Recommendation Report for Planning Permission for Works or Extension to a Dwelling

REF NO: BR/357/19/HH

LOCATION: 5 Mons Avenue
Bognor Regis
PO21 5JL

PROPOSAL: Proposed rear extension and loft conversion.

Proposed North Elevation

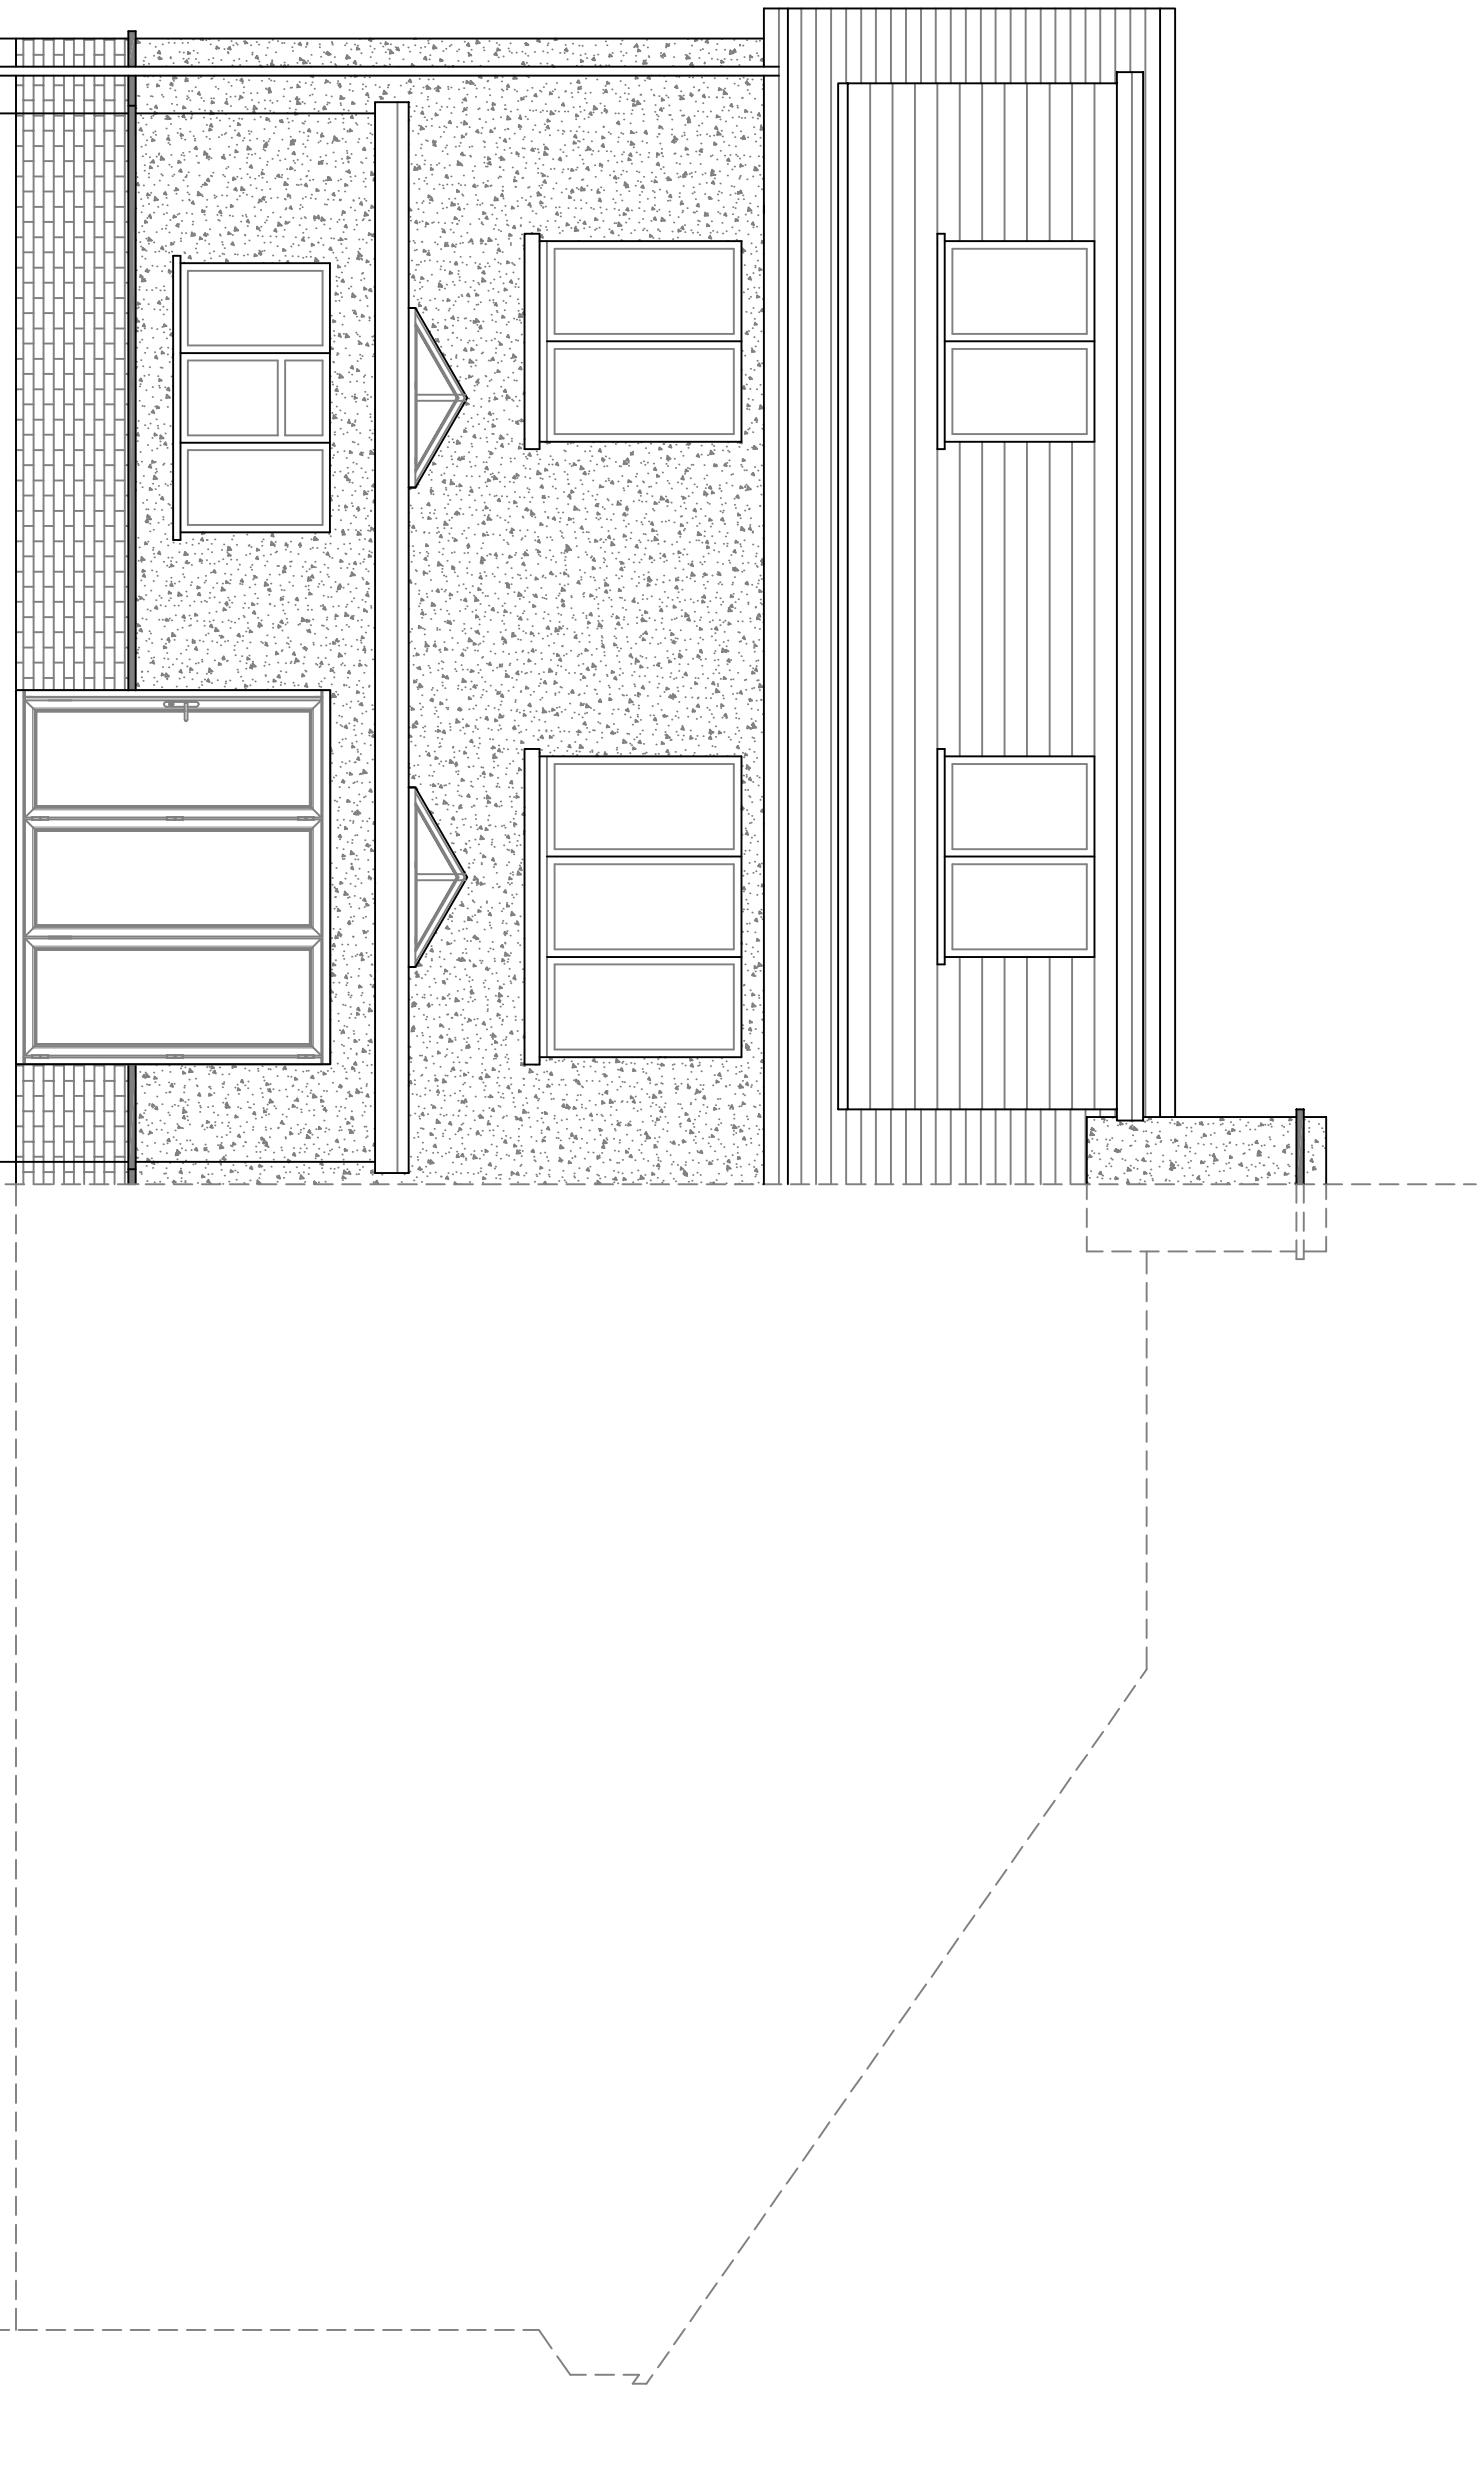
The extension and dormer will be situated to the rear of the property and is not likely to be visible from the wider area. To allow for the dormer, the roof will alter from hip to gable and therefore this element will be visible from the street scene.

The surrounding properties are similar in appearance with pairs of semi-detached dwellings, however the roof alteration is not considered to result in the property appearing significantly out of character in the area. A hip to gable can also be constructed under permitted development.

The extension to the rear and dormer is considered to appear subservient to the host dwelling and well integrated.

Proposed Ground Floor Plan

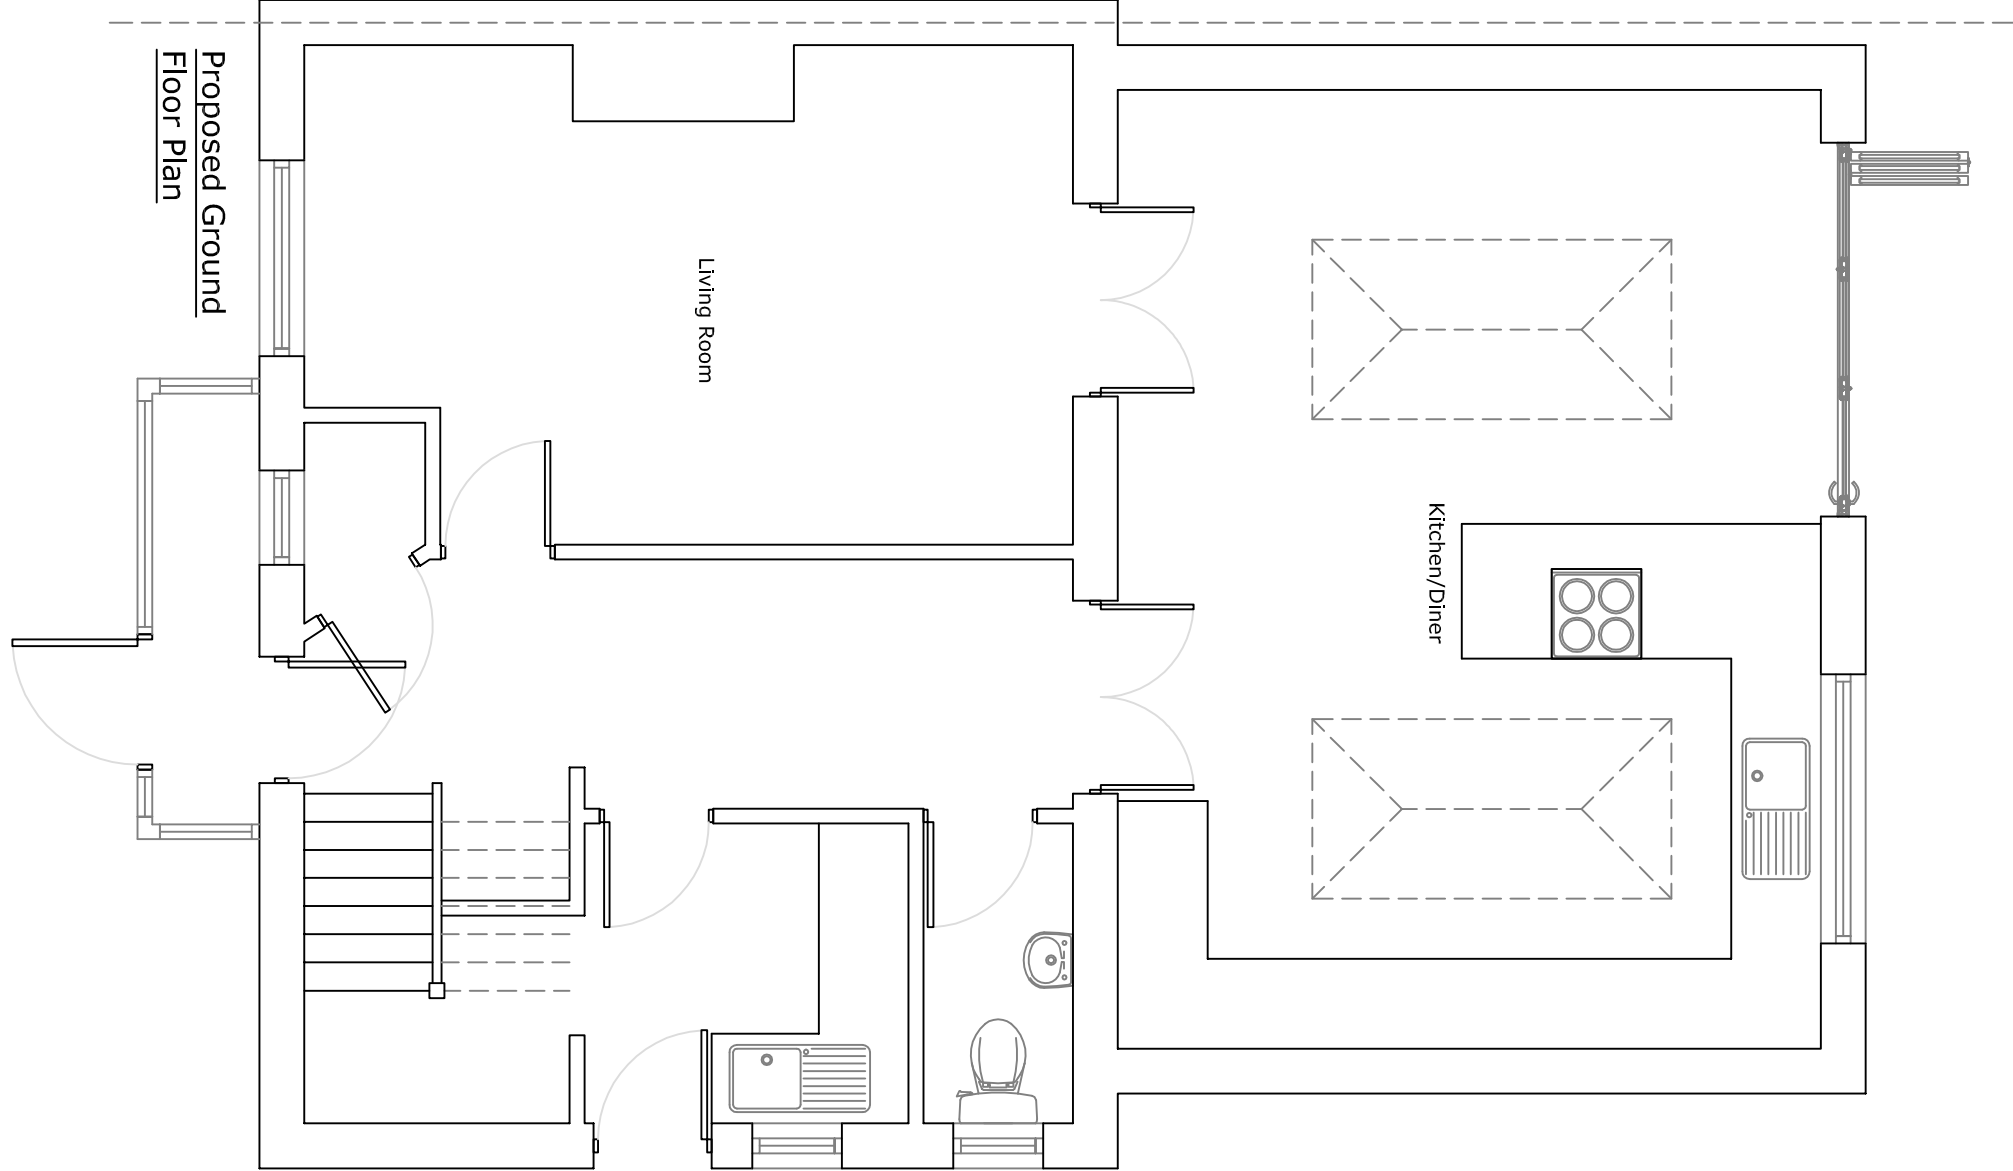
The extension will have a depth of 5m and a height of 2.7m to the eaves and 3m maximum with roof lantern. This will run along the full rear of property retaining approximately 0.3m to the western boundary and 1.7m to the east.

Whilst this does extend beyond neighbouring rear elevations and is likely to intersect a 45 degree line drawn from the centre of the ground floor window closest to the boundary at No.6, an extension could be constructed up 6m under extended permitted development rights and with no representation received, the development is considered acceptable.

The height is also modest and with boundary treatment in place, is not considered to result in adverse overbearing or overshadowing.

Proposed Loft Plan

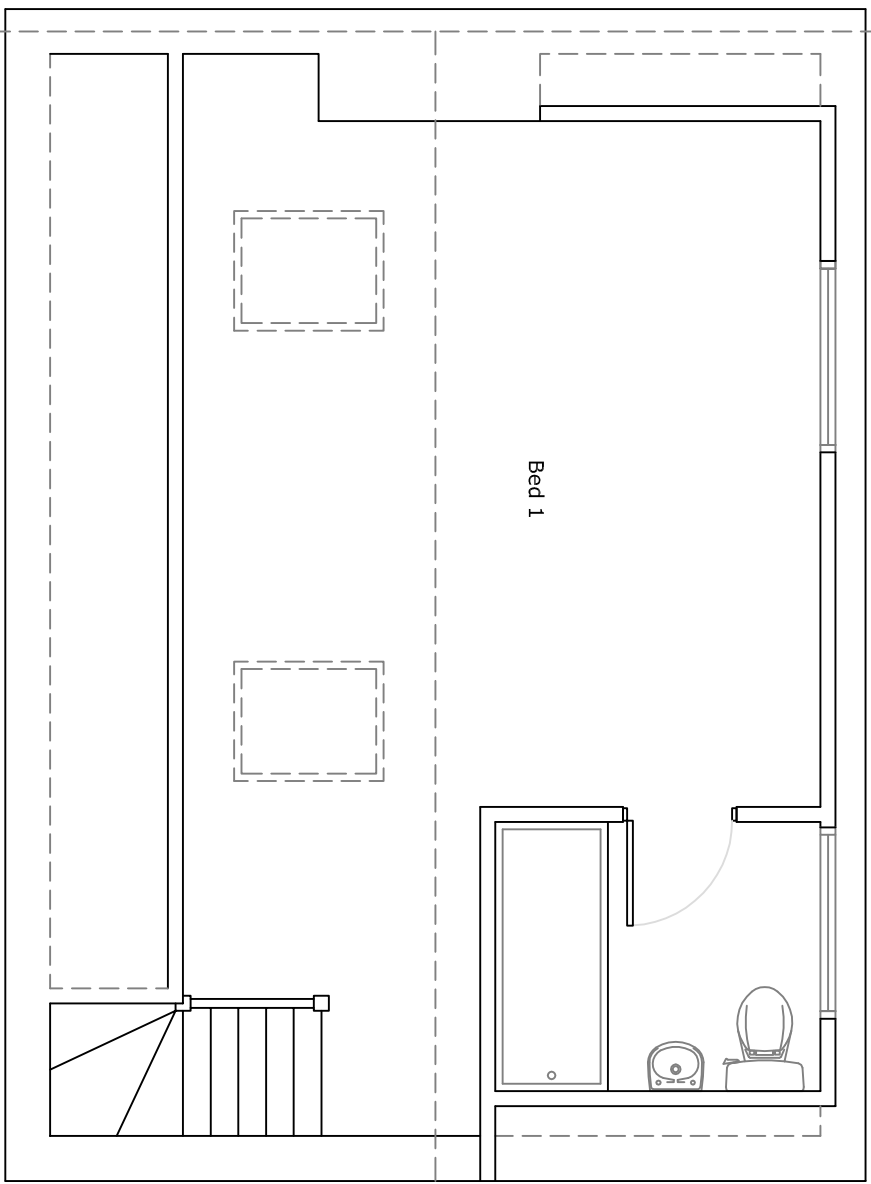
The dormer will have a depth of 2.4m and a height of 2m and run along the full roof slope. There will be 2 additional windows serving bedrooms. Whilst this would give rise to view over the neighbouring gardens, it would provide direct overlooking into neighbouring windows. The dormer is also likely to fall under permitted development.
